Drafted 14 December 2011

**Planning Application, Ribble Valley District
D3-11-0837 land off Pendle Drive, Calderstones Park, Whalley**

10-094-HT01-2

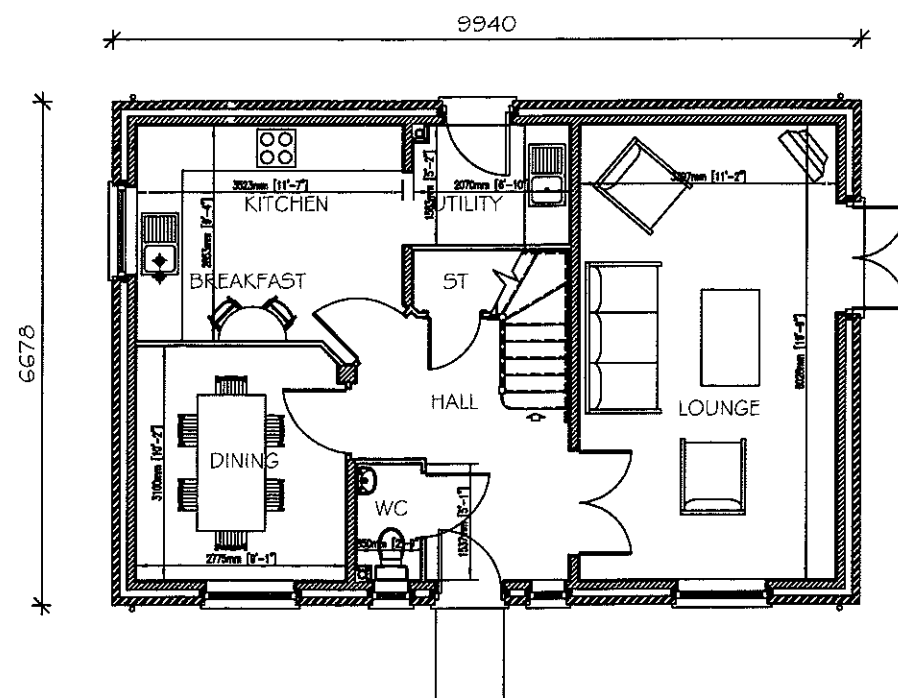
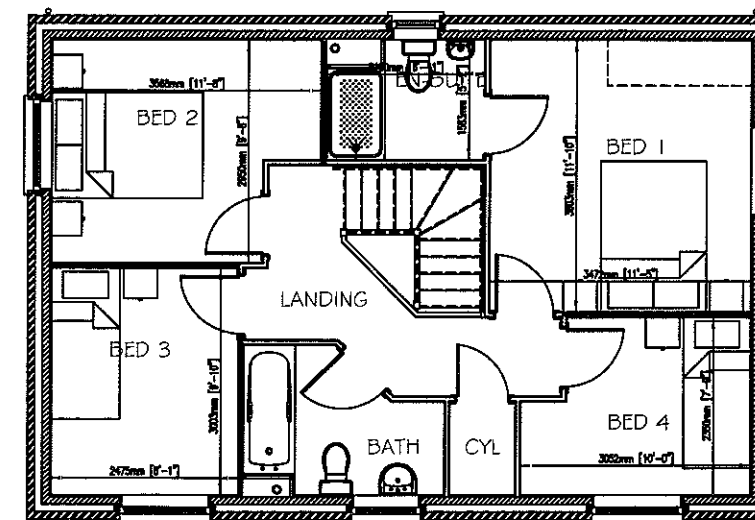
On this basis, the dimensions provided for some of the garages are not acceptable. As a minimum, the 4-bed design for house types D1251 and 1159 are acceptable as they provide a 5m by 2.5m parking area. While this does not allow for the minimal storage of materials, it does allow access for the majority of family vehicles.

10-094-HT04-2

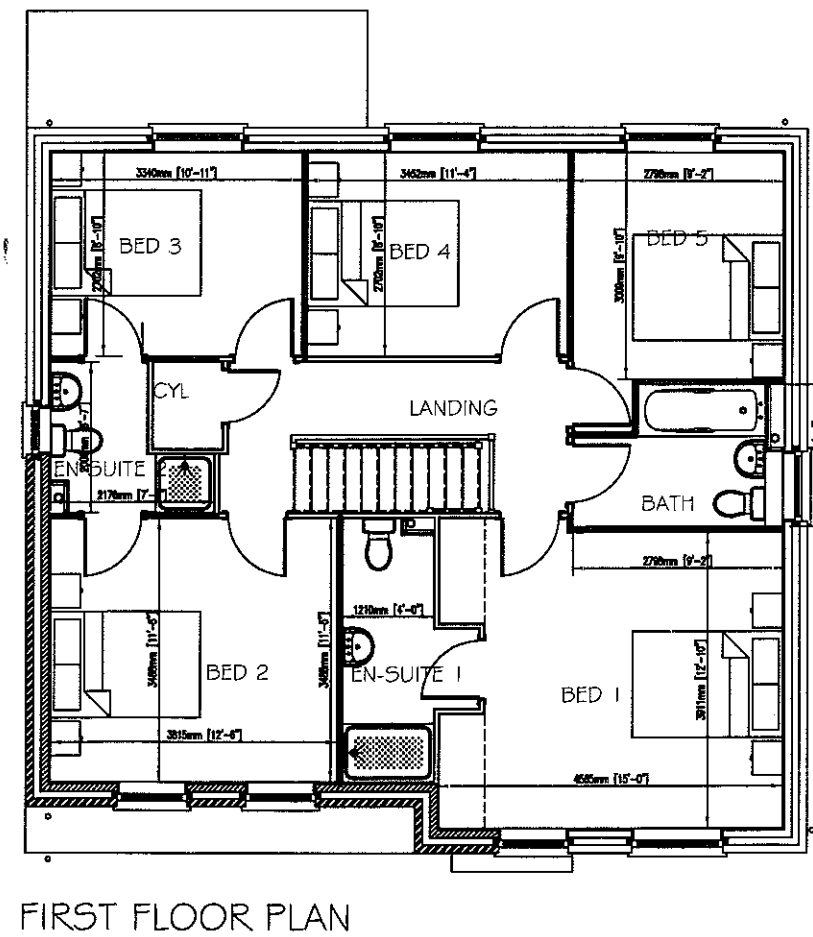
However, the 3-bed design for house type D914, the 4-bed design D1337 and the 5-bed double garage design for D1651 all fall below an acceptable threshold and would not safely accommodate a family car, or in the case of D1651, two family cars.

In determining a "family car" I have referred to models such as a Ford Mondeo Saloon, dimensions 4.84m by 2.08m, a BMW 5-series Saloon of 4.82m by 1.85m and a Renault Megane Saloon of 4.5m by 2.02m.

Therefore, the design of the garage provisions should be revised to insure that they can provide a safe and effective car parking space.
